Report of the Head of Planning, Transportation and Regeneration

Address 298 COLDHARBOUR LANE HAYES

Development: Use of outbuilding as a two bedroom self contained flat (Application for a Certificate of Lawful Development for an Existing Development)

LBH Ref Nos: 44828/APP/2019/1921

EXISTING GF LAYOUT
Scale 1:50

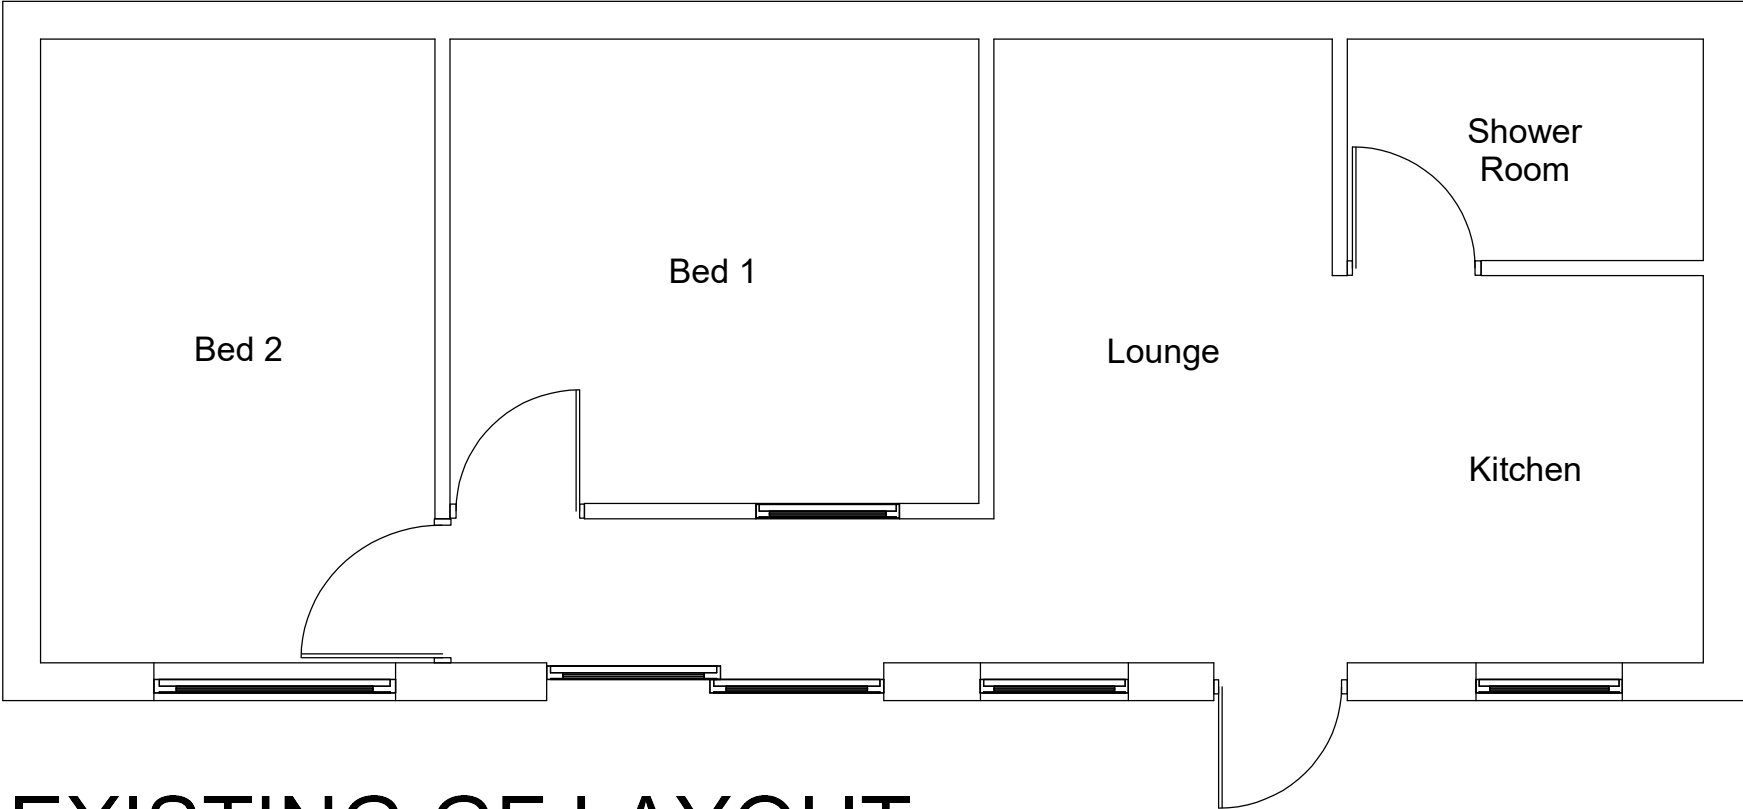
The applicant also provided 3 plans including a Block Plan and Existing Plan. The Block Plan shows a side access and the Existing Plan shows two bedrooms, a kitchen, lounge and shower room. No toilet area is shown.
